Norfolk Boreas Offshore Wind Farm

Statement of Common Ground

Broadland District Council

Applicant: Norfolk Boreas Limited
Document Reference: ExA.SoCG-3.D10.V5
Deadline 10
Date May 2020
Revision: Version 5
Author: Royal HaskoningDHV

CAWSTON HIGH STREET - INTERVENTION SCHEME  
Scale 1:500

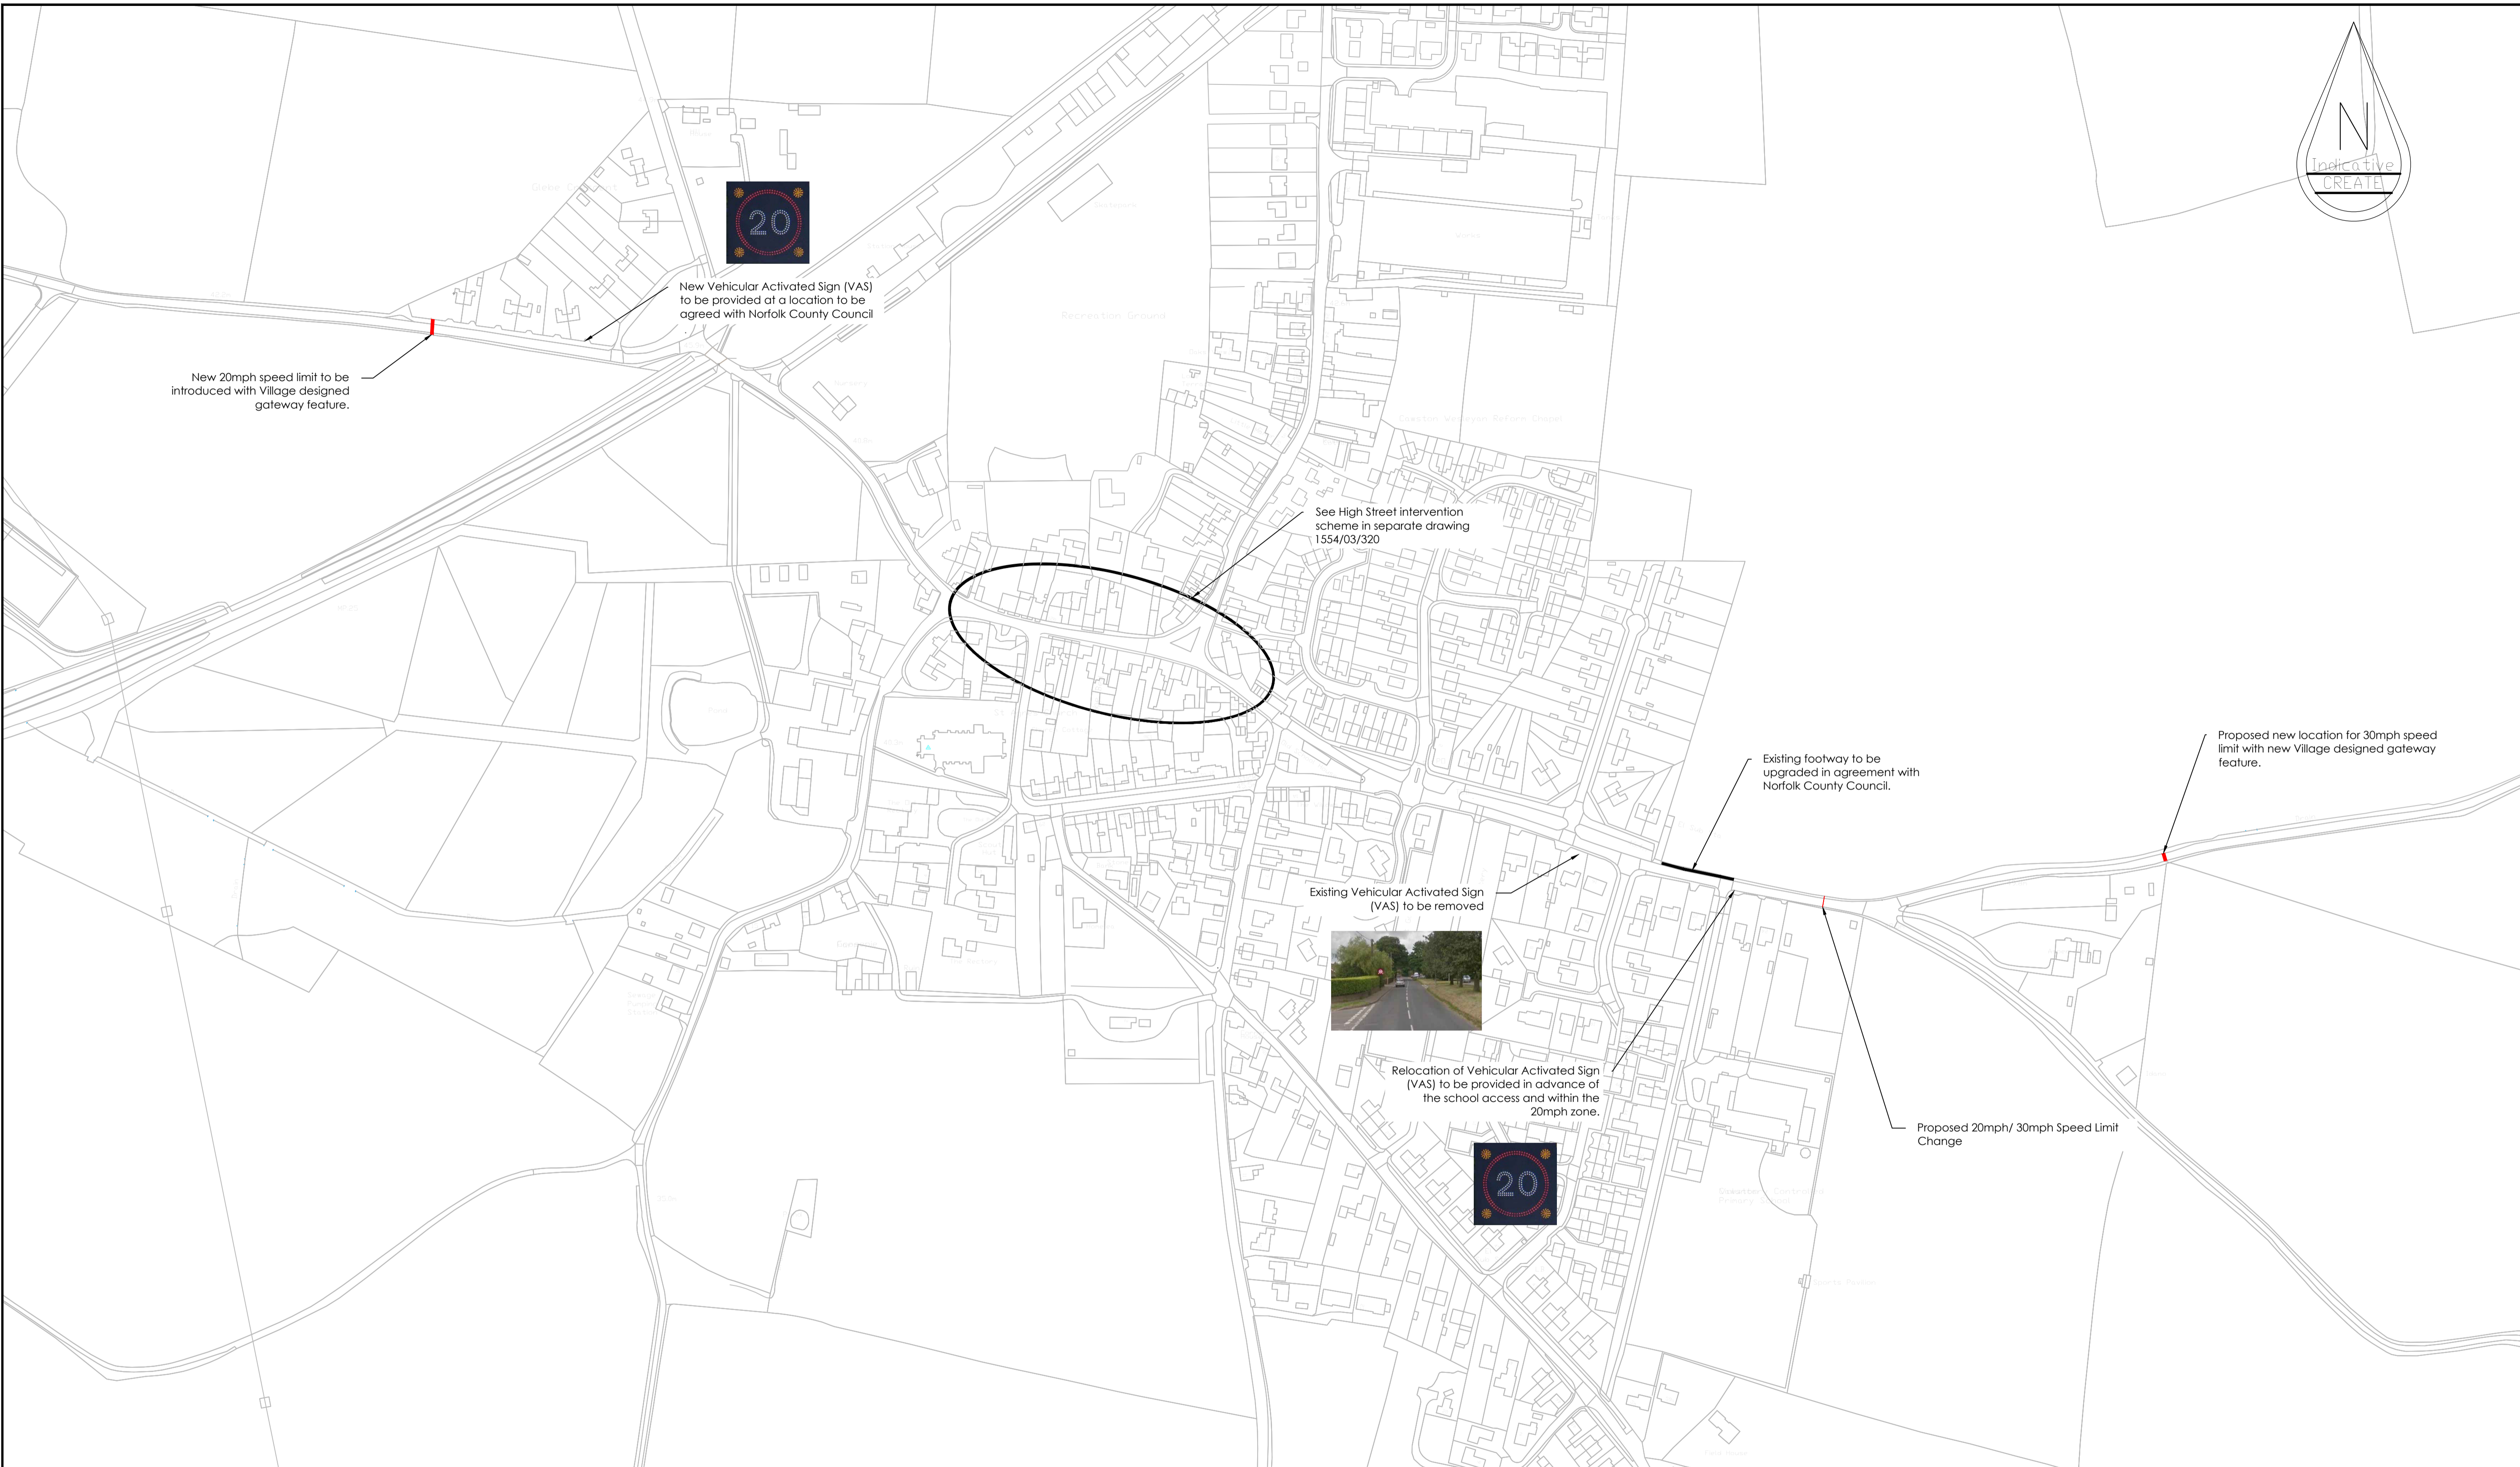
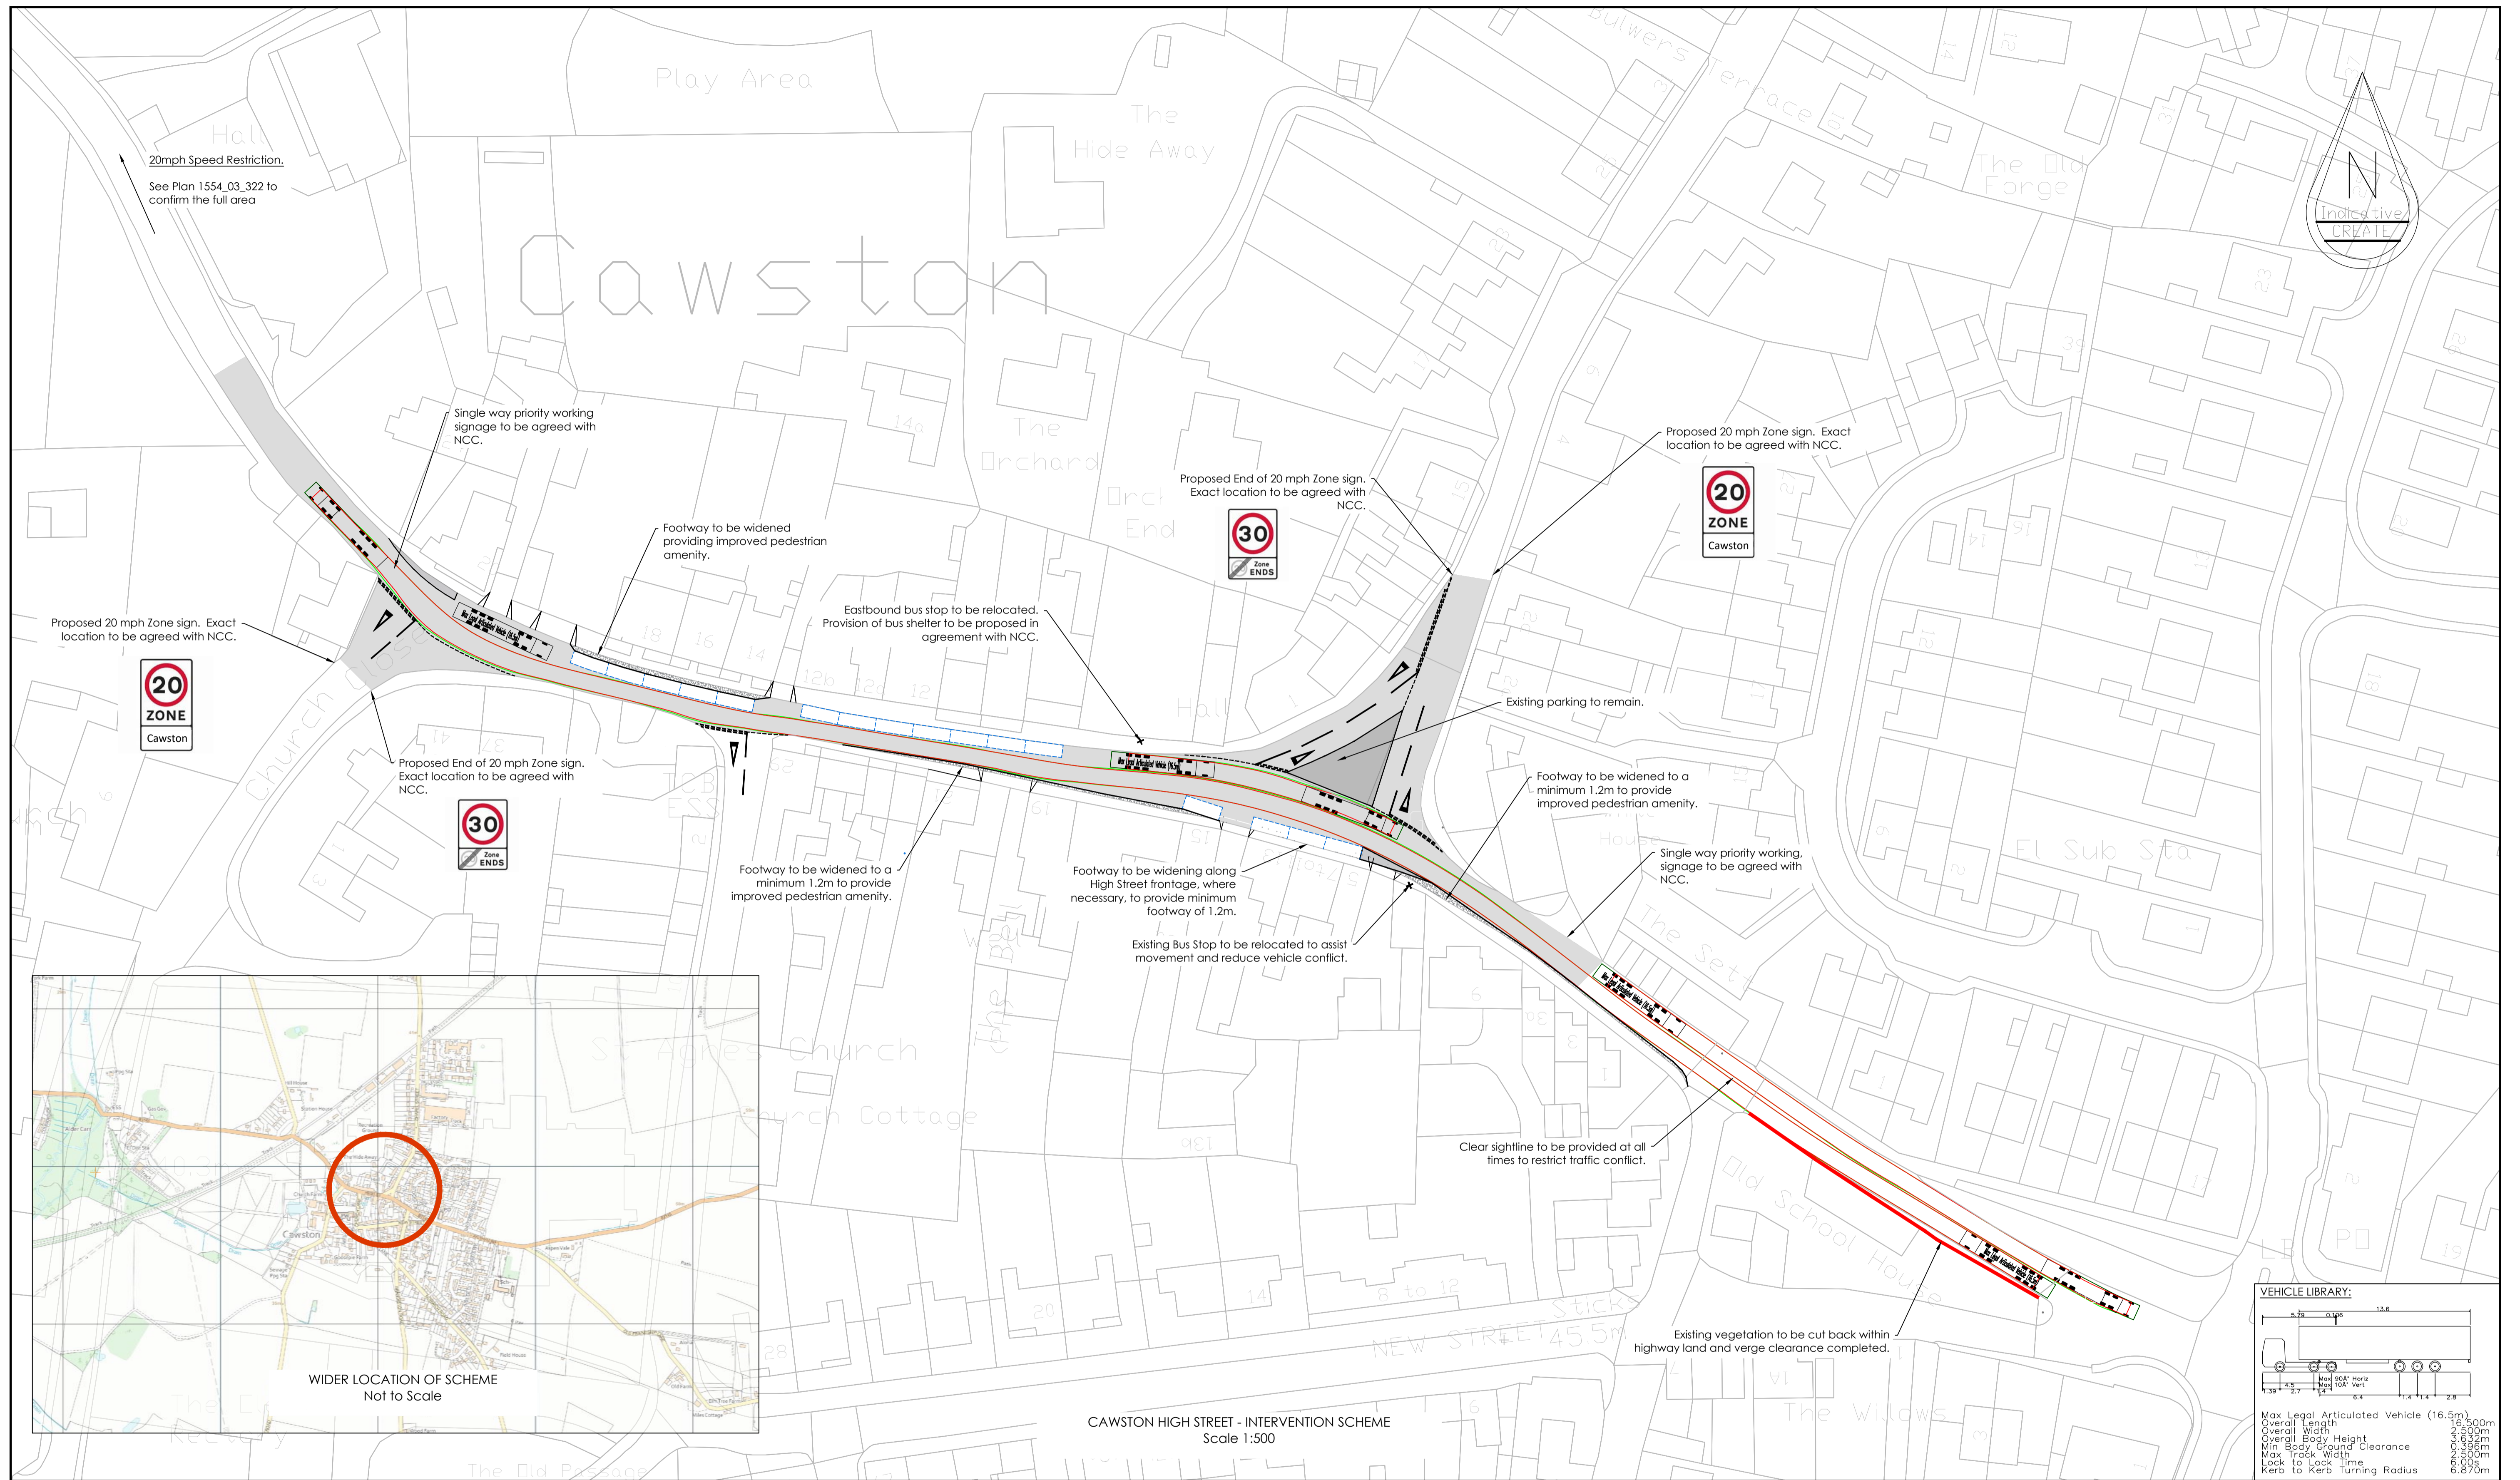
Topic	Norfolk Boreas Limited position	Broadland District Council position	Final position
	<p>findings are considered robust and with the inclusion of the identified mitigation measures, impacts have been reduced to non- significant.</p>		
	<p>B1145, Cawston An assessment of cumulative noise, vibration and air quality impacts associated with Norfolk Boreas and Hornsea Project Three along the B1145 through Cawston has been assessed (section 25.9 of ES Chapter 25 (APP-238) and section 26.8 of ES Chapter 26 (APP-239)). The assessment concluded that residual impacts related to noise, vibration and air quality are not significant.</p> <p>The traffic cap identified within the Application set out that cumulative HGV traffic must not exceed 260 daily HGV movements through Cawston, by reducing the Norfolk Boreas daily HGV movements to 133 (combined with the Hornsea Project Three peak of 127 daily HGV movements). However, the Applicant has sought to further optimise the construction programme to reduce the Norfolk Boreas Scenario peak traffic as low as practicable. As such, the Applicant is able to commit to a Norfolk Boreas peak of 112 (reduced from 133) daily HGV movements (in both the single project and cumulative scenario).</p> <p>These reductions do not change the findings of the CIA (the residual impacts remains minor adverse for noise impacts) but recognise the concerns of Cawston Parish Council and Broadland District Council and represent an effort to reduce these short-term peaks in construction traffic to as low as</p>	<p>The District Council recognise that the applicant has committed to further reduce the peak traffic levels in Cawston to Norfolk Boreas peak of 112 (reduced from 133) daily HGV movements (in both the single and cumulative scenario)</p> <p>BDC appreciate confirmation that the Traffic Management Plan will need to be agreed with BDC.</p> <p>In respect of the findings of the Clarification Note on the potential noise, vibration and air quality effects of the Cawston HIS.</p> <p>In terms of the noise effects it is considered that the basic noise level calculation assumes a speed of 20mph in free flowing traffic, in free-field conditions, with no account taken of the distance between source and receptor, nor façade or reflection effects. It is also not clear from the report whether the applicant has applied the CRTN</p>	<p>The assessment for cumulative impacts through Cawston for air quality and vibration are agreed by both parties however BDC still have concerns regarding potential impacts of traffic noise.</p>

Topic	Norfolk Boreas Limited position	Broadland District Council position	Final position
	<p>practicable. This further commitment is captured in the Outline Traffic Management Plan.</p> <p>With the assessments of potential cumulative noise, vibration and air quality impacts along the B1145 through Cawston and the further commitment to reduce Norfolk Boreas peak daily HGV movements to 112, the assessments findings are considered robust, and with the inclusion of the identified mitigation measures, impacts have been reduced to non- significant.</p> <p>Mitigation is proposed for Link 34 (B1145), including the development of a Highways Intervention Scheme and is captured within section 4.3.1 of the Outline Traffic Management Plan (OTMP) (document reference 8.8, Version 4) and secured through DCO Requirement 21. Mitigation includes a cap on the maximum number of daily HGV movements, temporary speed restrictions, resurfacing the road, incorporation of formalised parking and parking restriction, and priority warning signs. Also includes prohibition of HGV deliveries during term time school pick up and drop off times (7:30am – 9:00am and 3:00pm – 4:00pm, Monday to Friday) and from 6pm to 9am (in line with parking restrictions).</p> <p>Norfolk County Council have indicated (during a meeting held on the 16th March 2020) that no further amendments were required to the HIS and there were no remaining technical objections. Following agreement on the HIS the Applicant has produced a Clarification Note [REP8-028],</p>	<p>definition of HGV’s i.e. all vehicles with an unladen weight of 1525kg and above. Furthermore the HIS requires all vehicles to brake, stop, idle and accelerate on multiple occasions along the High Street. It is therefore considered that it does not describe the actual noise levels that will be experienced by residents and pedestrians in the centre of Cawston, which will possibly be 4dBA higher when taking the façade and reflective effects as well as the closeness of dwellings to the road into account.</p> <p>In terms of the vibration effects it is considered that these are acceptable based on the results of the H3 monitoring. It is suggested that the applicant undertakes its own measurement surveys prior to the commencement and approval of the construction traffic management plan.</p> <p>In terms of the air quality effects it is considered to be acceptable.</p>

Topic	Norfolk Boreas Limited position	Broadland District Council position	Final position
	<p>submitted at Deadline 8, which provides further information on the potential noise, vibration and air quality effects of the HIS which would serve to reduce traffic impacts through Cawston (Link 34, B1145).</p> <p>The findings of the road traffic noise assessment concluded that for Norfolk Boreas alone and cumulatively with HP3 impacts will be no greater than minor adverse, and therefore will have no significant effect upon the receptors in the vicinity of Link 34.</p> <p>The vibration assessment concluded that the predicted vibration impacts on humans are currently below the threshold level “Less than Low probability of adverse comment”. The predicted vibration impacts on human receptors as a consequence of implementing the HIS are minor adverse, which is not significant in EIA terms. Predicted vibration impacts on buildings (including those designated as listed buildings) are below the threshold level for cosmetic damage at each of the four receptor locations (representative of listed and residential dwellings along link 34). Although it is noted the frequency of vibrational transfer events from HGV movements along Link 34 to each building during the scheme mobilisation hours will increase, the predicted impacts are minor adverse, which is not significant in EIA terms.</p> <p>The air quality assessment concluded that the pollutant concentrations were well below the respective annual mean air quality Objectives (40µg.m-3 for NO2 and PM10,</p>

Topic	Norfolk Boreas Limited position	Broadland District Council position	Final position
	<p>25µg.m-3 for PM2.5) at all receptors identified. Therefore, impacts were assessed as not significant</p> <p>This combined suite of measures for Link 34 will serve to mitigate the effects of either Norfolk Boreas or Hornsea Three alone or both projects together. Whichever project progresses to construction first will introduce the measures and the final project will remove the mitigation at the end of construction. The scheme will be implemented under both scenarios, under Scenario 1 Norfolk Boreas will retain or reinstate the scheme from Norfolk Vanguard.</p> <p>In accordance with DCO Requirement 21 the final Traffic Management Plan will be approved the relevant planning authority.</p>		
	<p>The assessment of impacts of both scenarios for construction, operation and decommissioning presented in section 25.8 of ES Chapter 25 (APP-238) and section 26.7 of ES Chapter 26 (APP-239) is appropriate and, assuming the inclusion of the mitigation described, impacts from noise, vibration and air quality are non-significant in EIA terms.</p>	<p>Agreed</p>	<p>It is agreed by both parties that the assessment of impacts for construction, operation and decommissioning presented is appropriate</p>
